A46 Newark Bypass

Statement of Common Ground with Think Again A46 Winthorpe Action Group

**Statement Of Common Ground with
Think Again A46 Winthorpe Action Group - TA**

Version	Date	Status of Version
Rev 0	October 2024	Deadline 1

Drawing file: TR010065 / TR010065-000156-TR010065_A46 Newark Bypass_6.2 Figure 2.4 - Locations of Temporary Works Areas Required During Construction.pdf

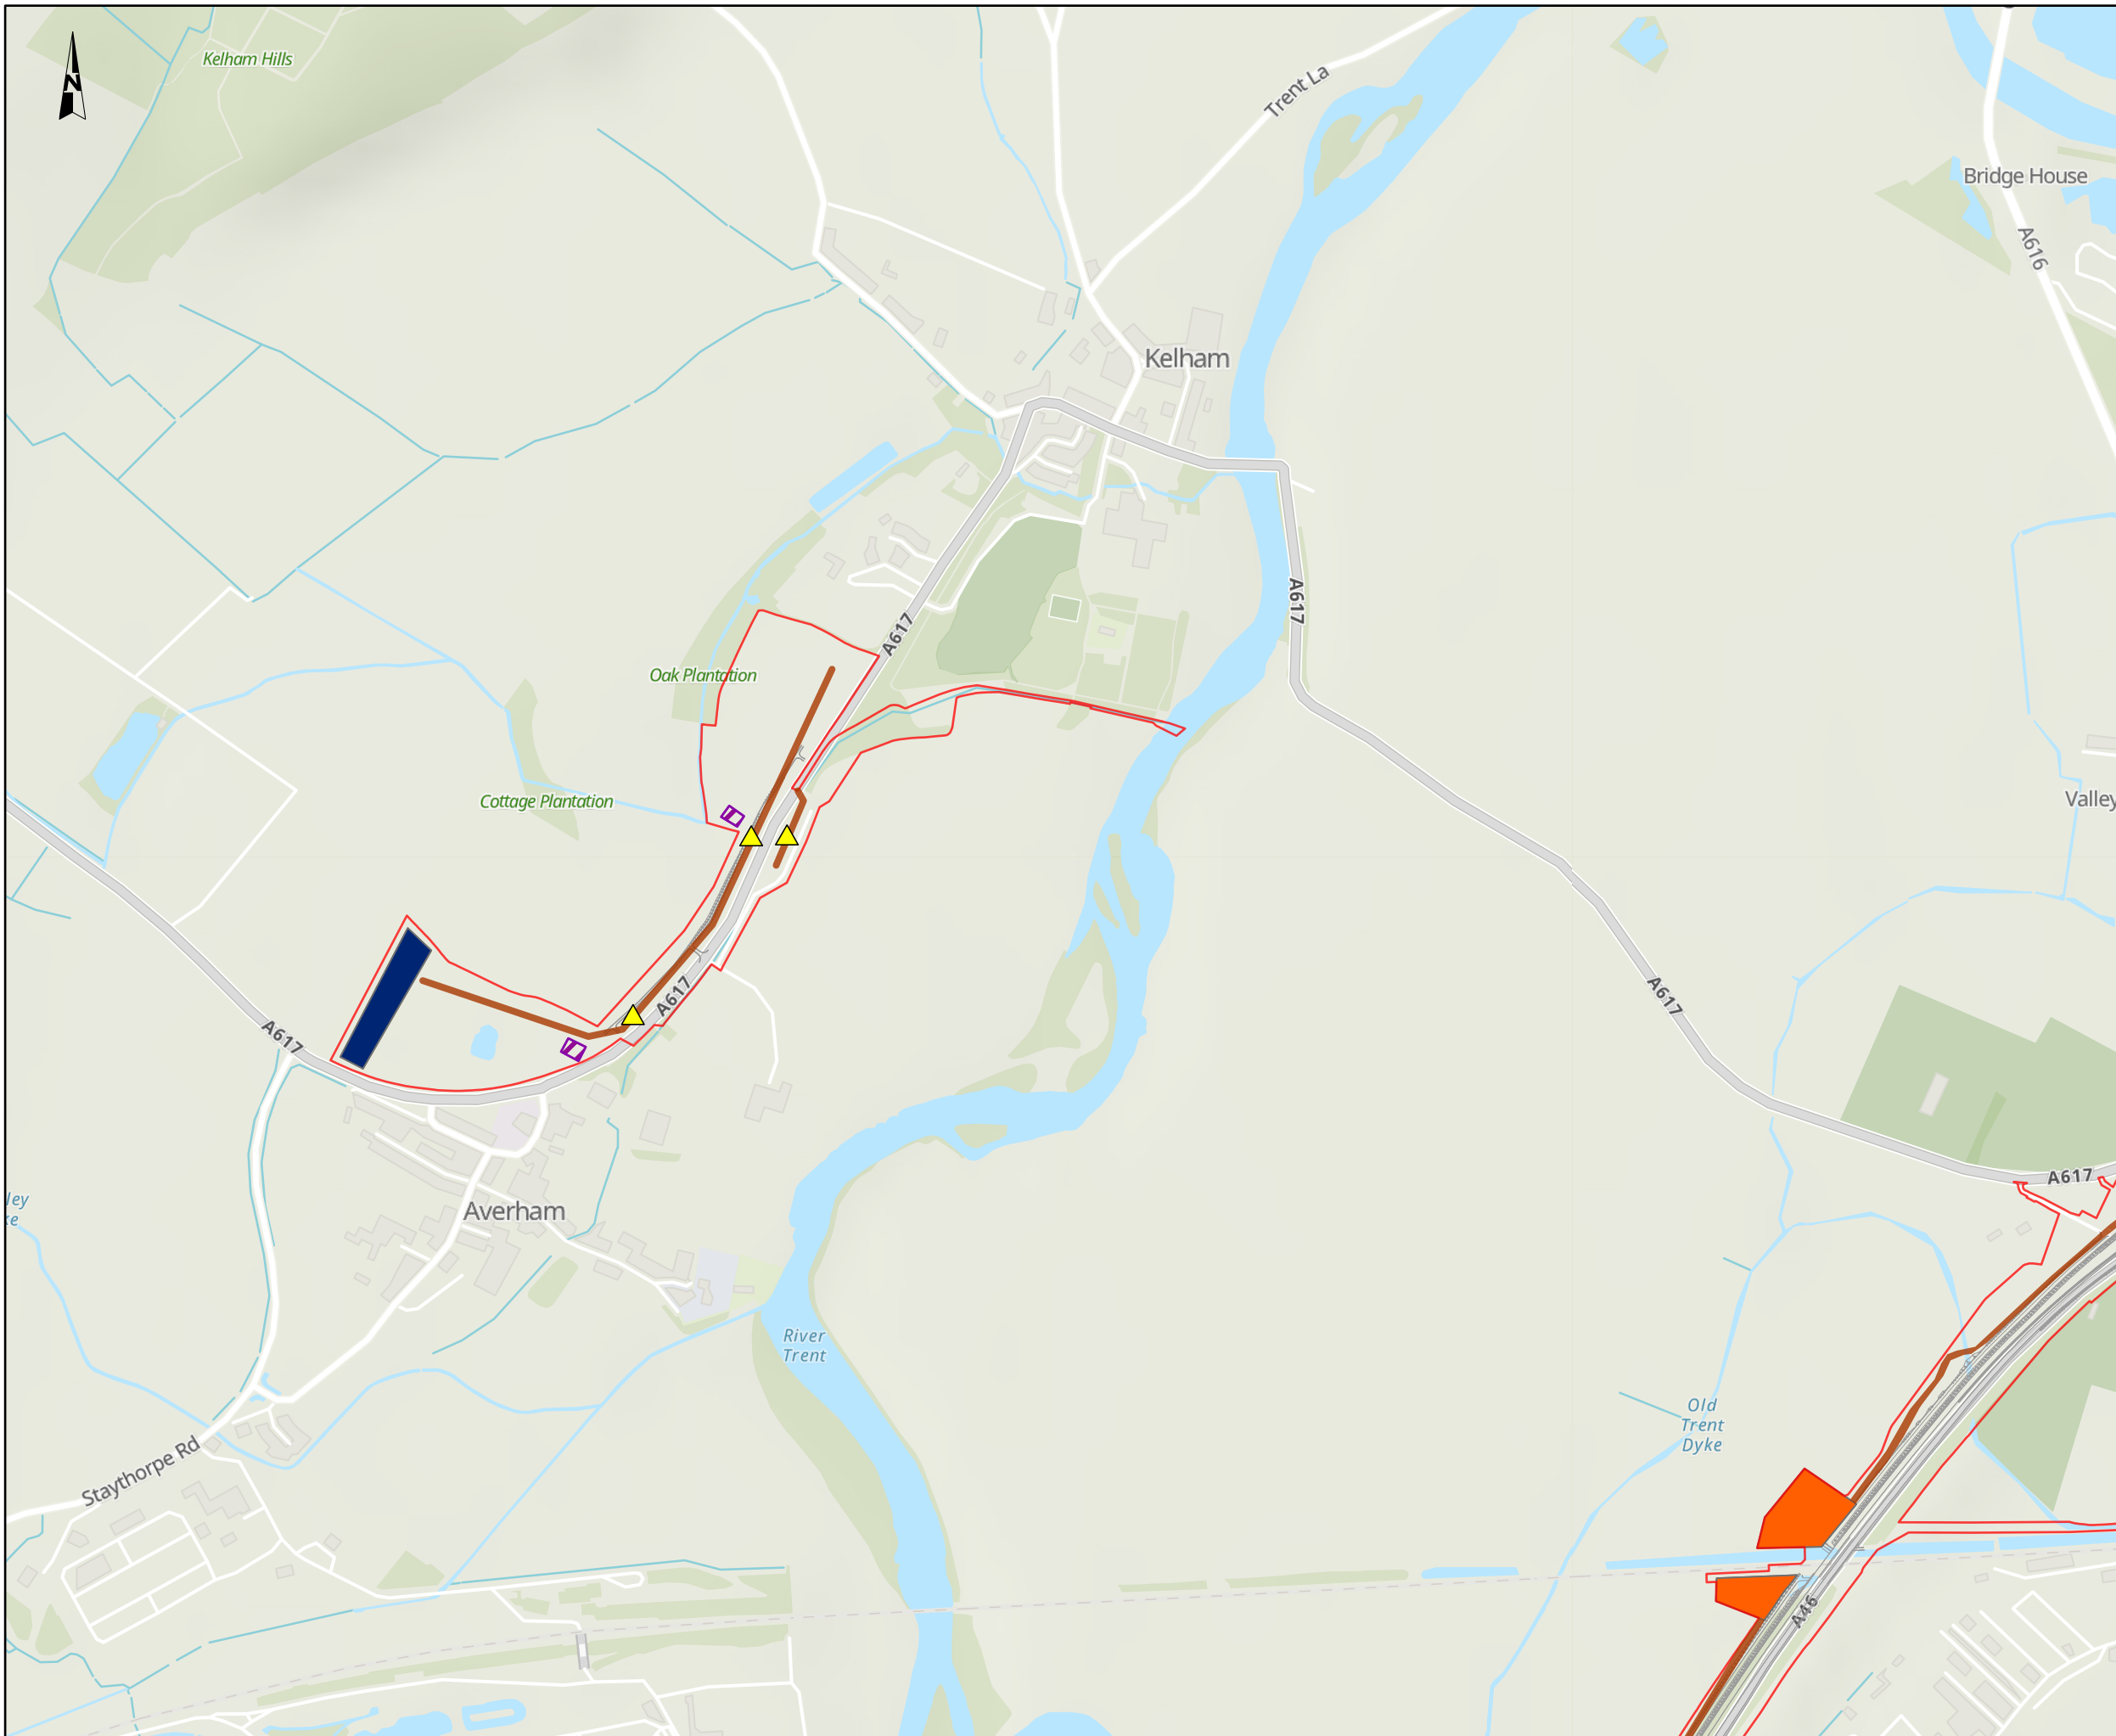
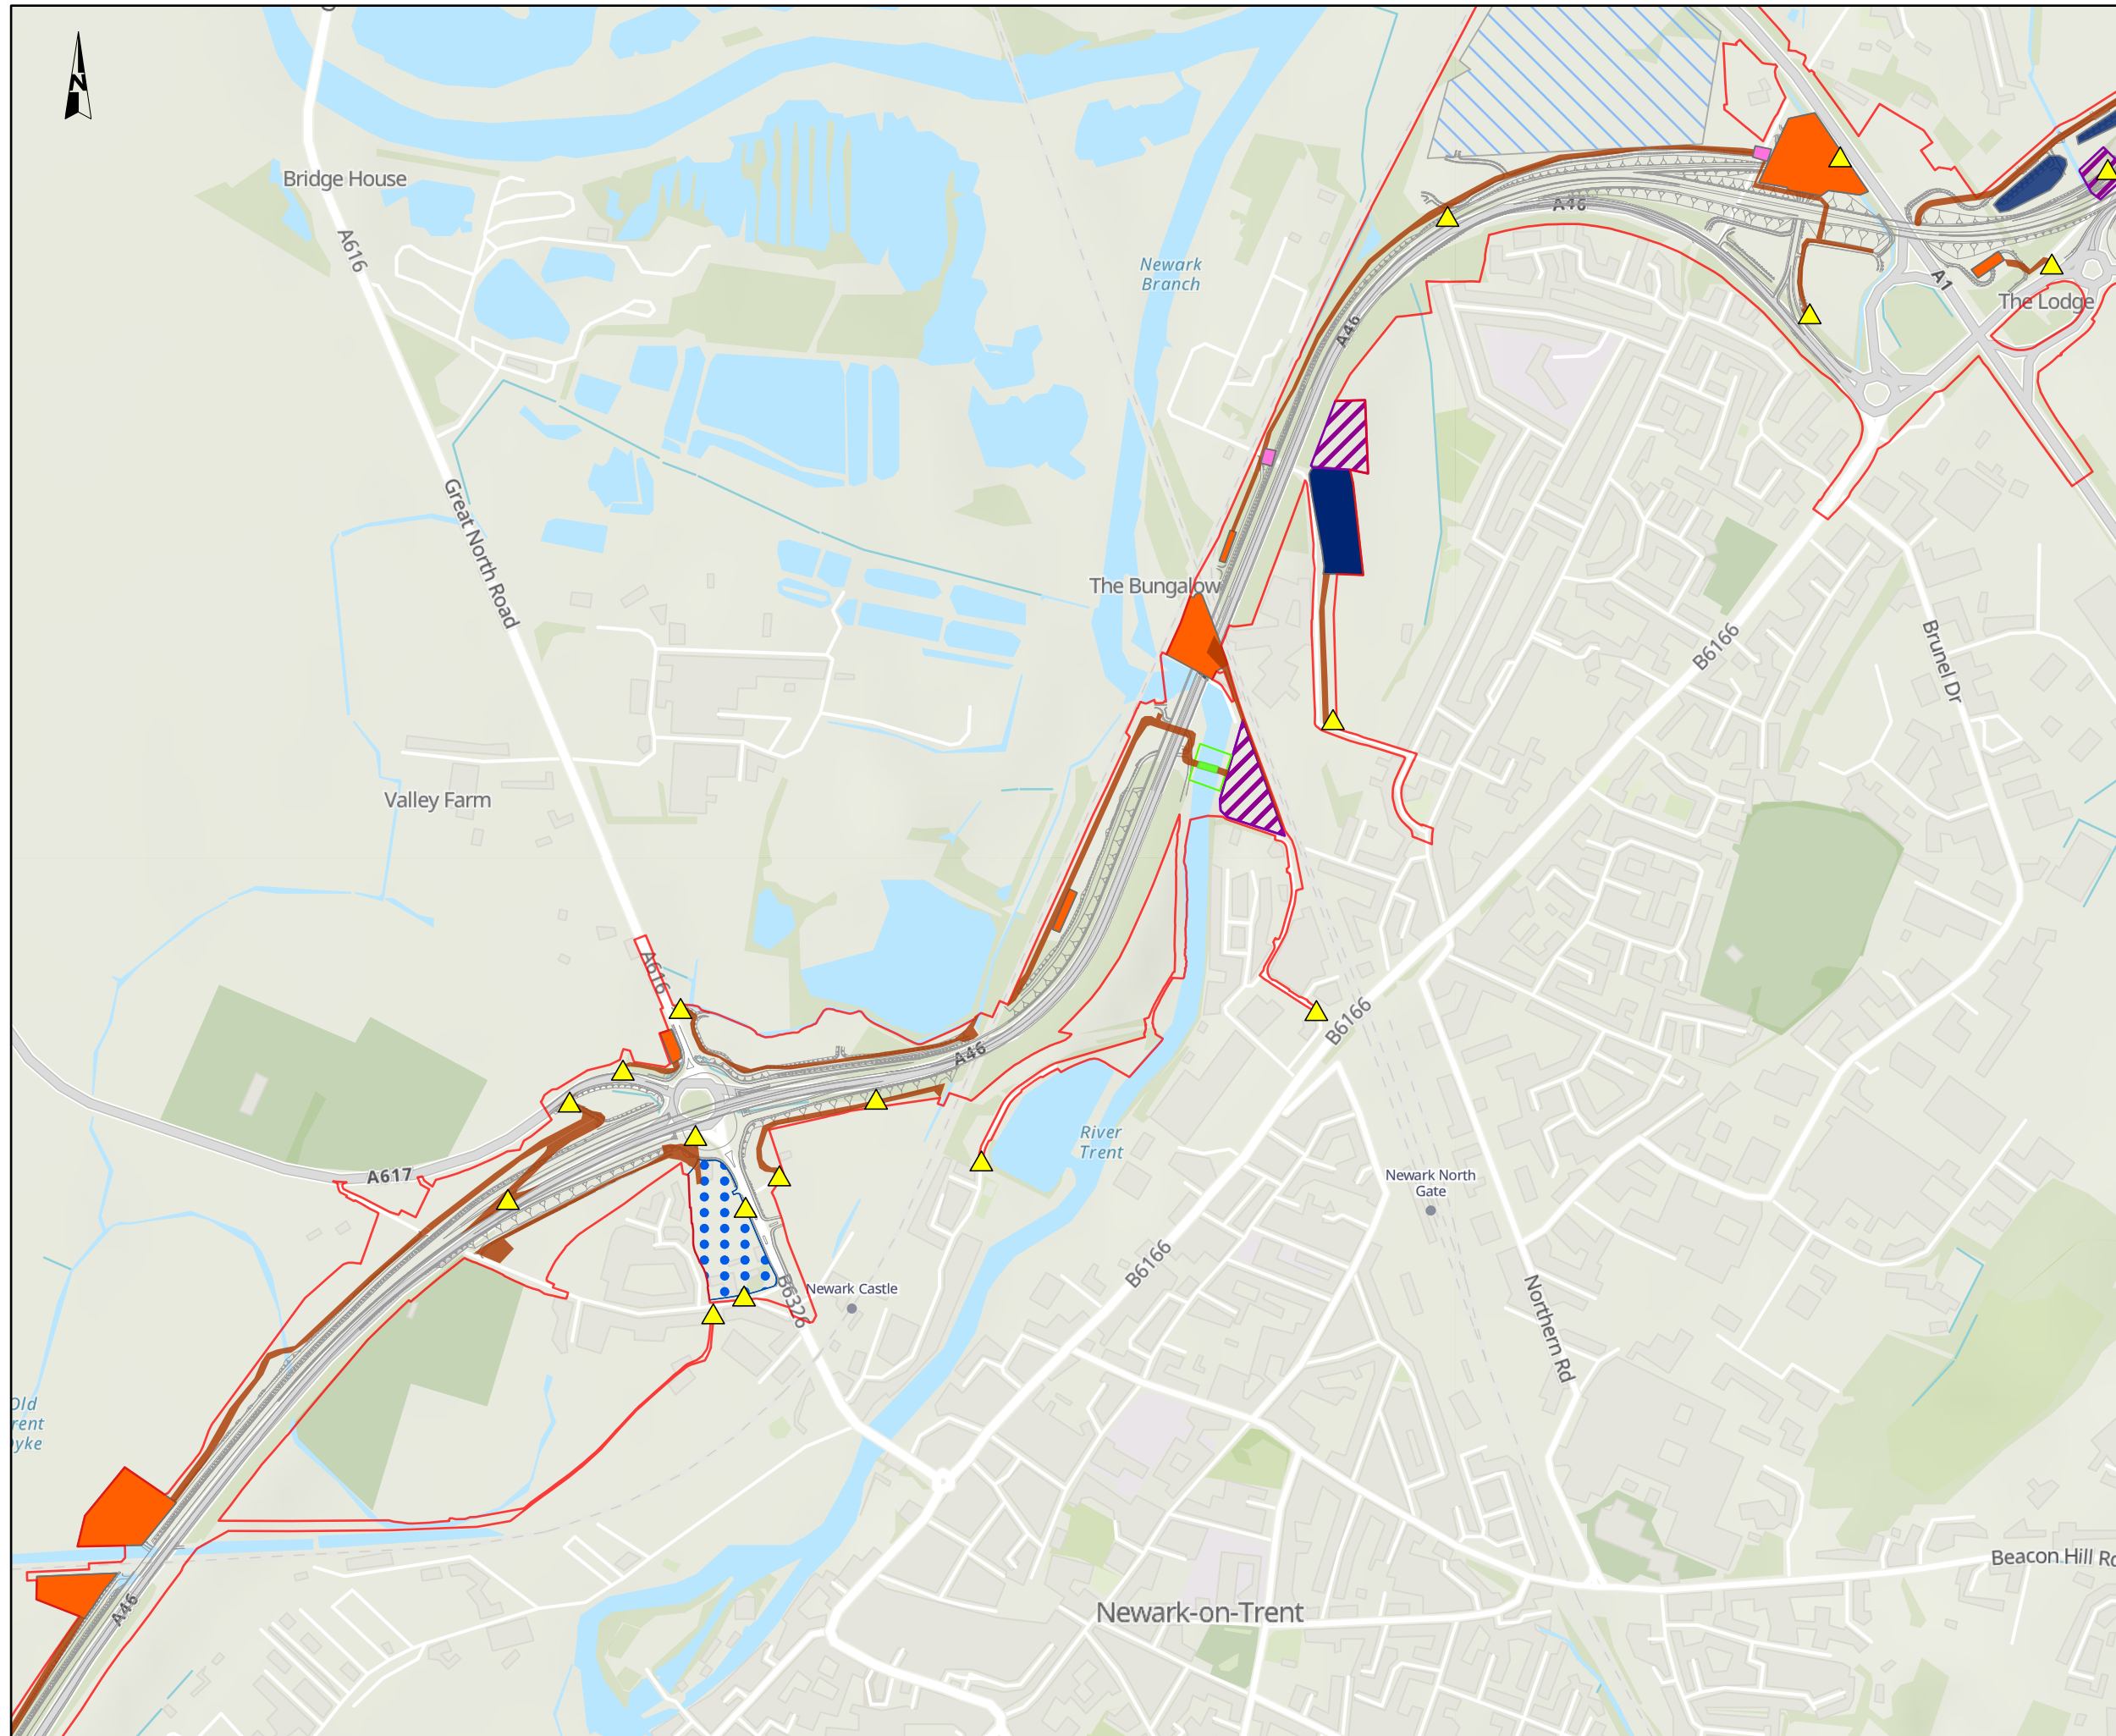
20.	Construction Compounds	<p>Figure 2.4 Locations of Temporary Works Areas Required During Construction of the Environmental Statement Figures [AS-027]</p> <p>Table 2-6 in Chapter 2 The Scheme of the Environmental Statement [APP-046]</p>	What construction compounds and works access facilities will be located in the Winthorpe area?	The location of the construction compounds and works access areas within the Winthorpe area are detailed on Figure 2.4 Locations of Temporary Works Areas Required During Construction of the Environmental Statement Figures [AS-027] and in Table 2-6 in Chapter 2 The Scheme of the Environmental Statement [APP-046].	Agreed	24/09/2024
